CONSULTEE RESPONSE (Council's Arboriculturist)

Reference: BN/68/22/PL

Proposal: Erection of 4 x 4-bedroom houses. This application is a Departure from the Development Plan and is in CIL Zone 3 and is CIL Liable as new dwellings

Location: Land adjacent to Wayside, Eastergate Lane, Eastergate, PO20 3SJ

Site layout plan (coloured)
 Eastergate Lane, Eastergate PO20 3SJ 1194-A-06B

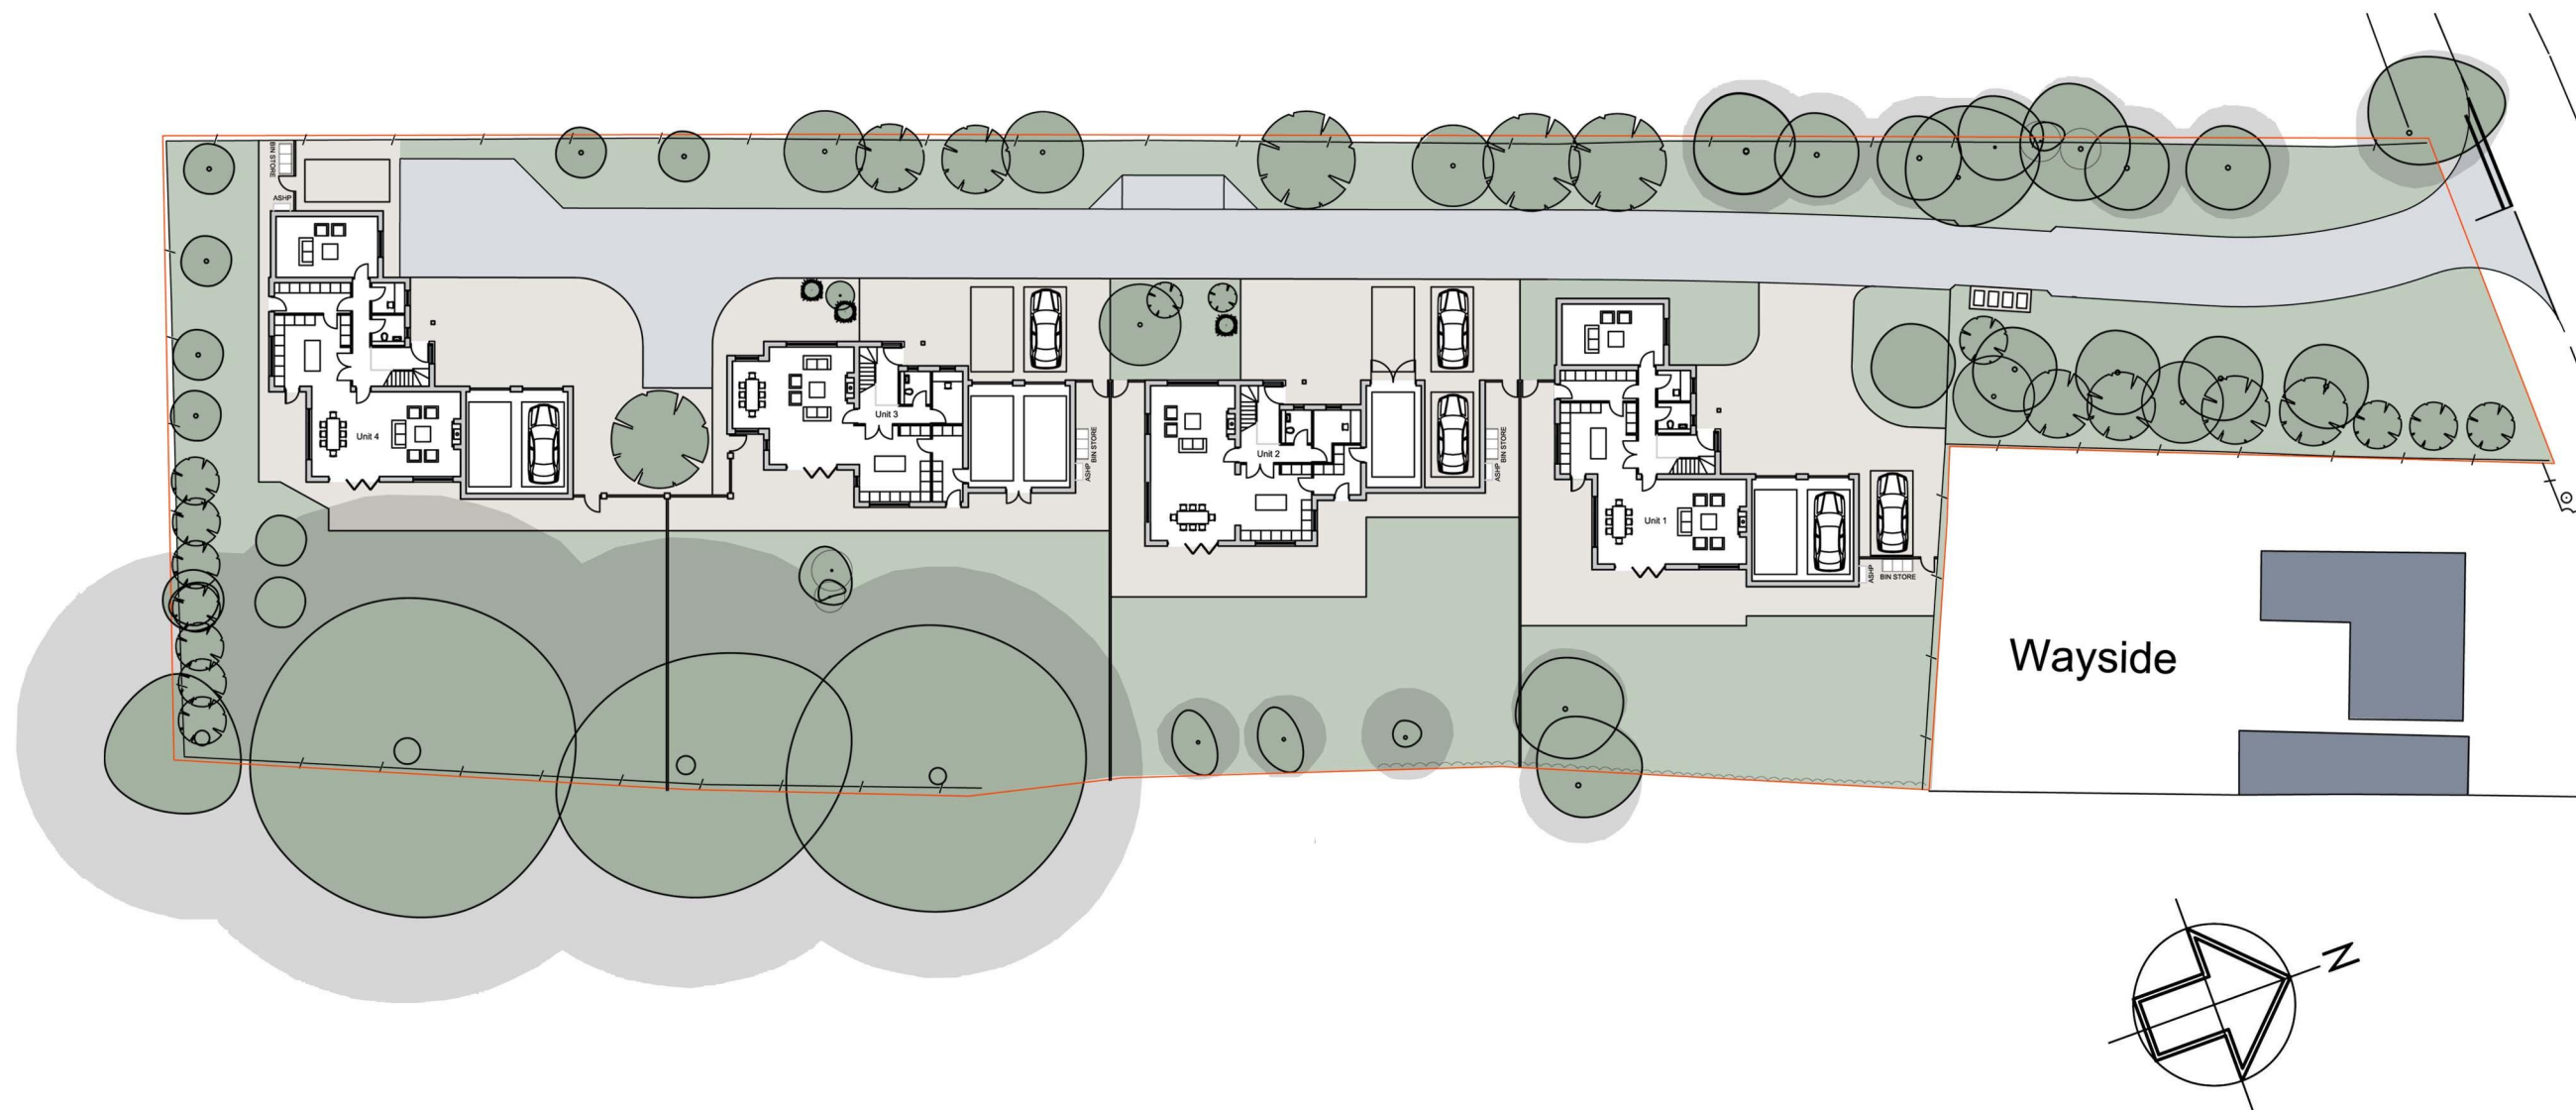
The former are rightly classified as Category A trees, being also of high landscape value and previously made individual subjects of Tree Preservation Order (-/BN/1/20). They will cast considerable morning shade across gardens and dwellings (units 3 & 4). The introduction of main garden areas beneath the canopy of these large, mature trees is ill-conceived. In addition to heavy shade bearing, nuisance from persistent deposits of catkins, leaves and fruit for three seasons of the year will likely result in applications coming forward for substantial pruning back of their crowns on west aspect.

The general 'principle of development' as described is achievable without undue detriment to retained trees but it requires a more sympathetic and less intrusive layout with an emphasis on keeping construction and any increase in frequency of land use (gardens) away from high value (Category A/TPO) trees.

Existing Trees to be Removed

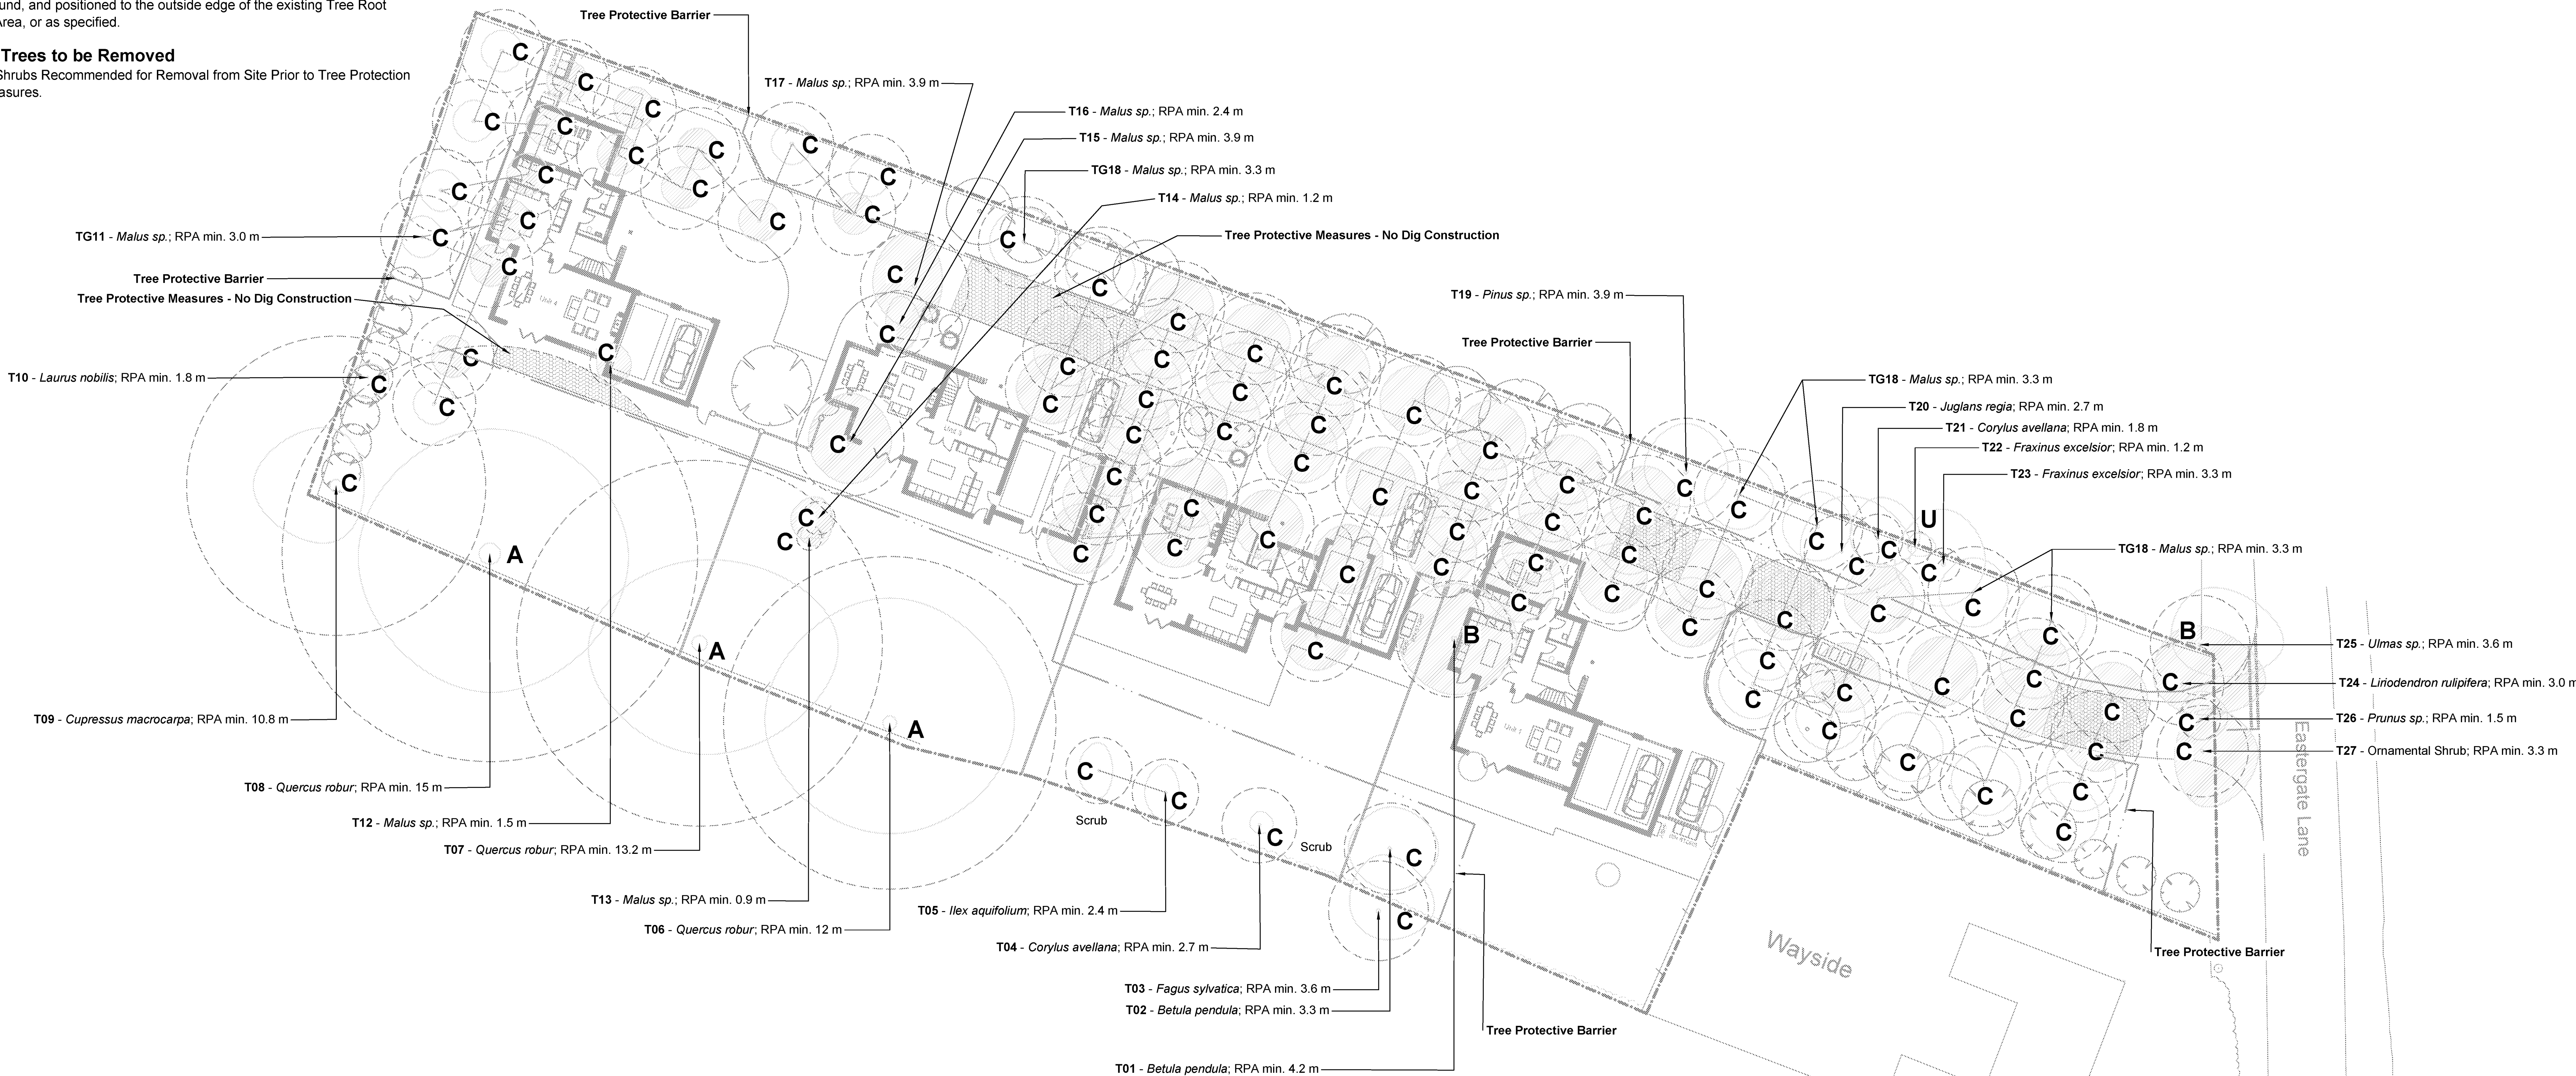
I am not satisfied any overriding justification exists for construction within the nominal root protection area (RPA) of these oak trees, especially that (T08) which has been capped at 15metres. We require an effective buffer zone (usually a minimum of 2metres) beyond the RPA for such high value trees, as promoted and detailed within our Supplementary Planning Documents. Those give instruction for avoiding Root Protection Area (RPA) incursion and providing further insurance with the use of buffer zones. **Arun District Public Open Space, Playing Pitches and Built Facilities** (Appendix 9) and **Arun Design Guide** (E.02 Landscape Structures & Trees, p48) - [Supplementary Planning Documents \(SPDs\) and other guidance | Arun District Council](#).

Oak trees (T06-T08 incl.) are strategically important for the accrual of ecological and environmental benefits for this site and its environs so ought to represent a major constraint to development. They are arguably of emerging veteran status and should be afforded enough room to prevent a need arising for 'hazard mitigation pruning' that would diminish their status in the landscape.
